Application No: A/25/21/A
Site Address: Land South of Water Lane Angmering
Description of works: Erection of 5 No. non-illuminated Banner flags and 10 No. non-illuminated Totem signs.

Thank you for your internet representation made on 11th March 2021 which has been recorded as an objection with the comments as follows:

DWH SUPPORT RED
C31 M87 Y66 K25

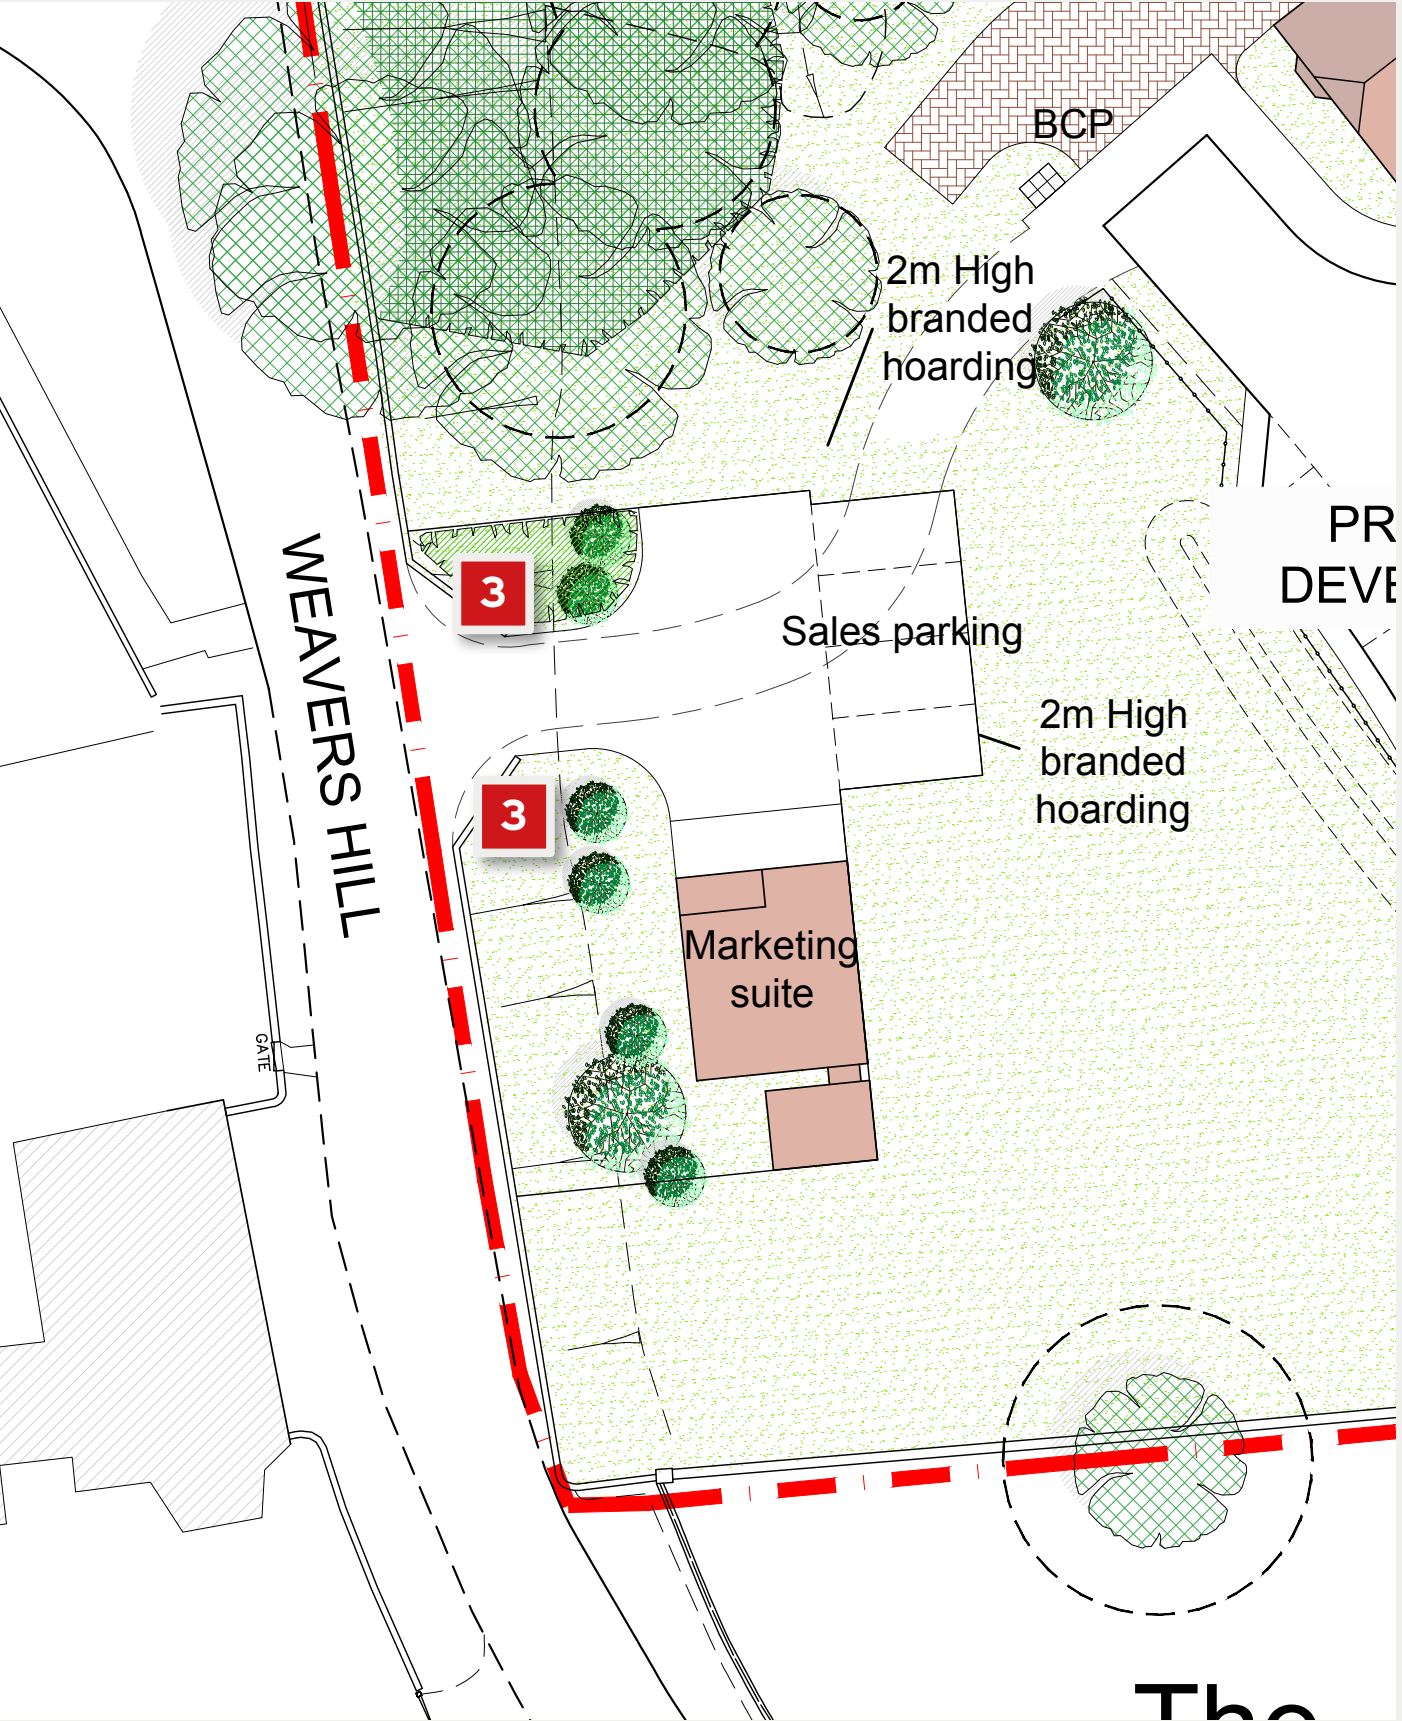
1. In accordance with NDP checklist this application contravenes EH1 as it will have a detrimental visual effect on the Angmering Conservation Area which it adjoins.
2. Road Traffic Safety. The use of flags and advertising boards could constitute a distraction to drivers on a very narrow lane that has shared use with pedestrians, vehicles and public transport. The proposed site is also immediately to the north blind corner.
3. Noise pollution. The siting of the flags may cause a noise disturbance to two residential properties, both within the Angmering Conservation Area. One directly across from the proposed site and a second alongside the site to the south
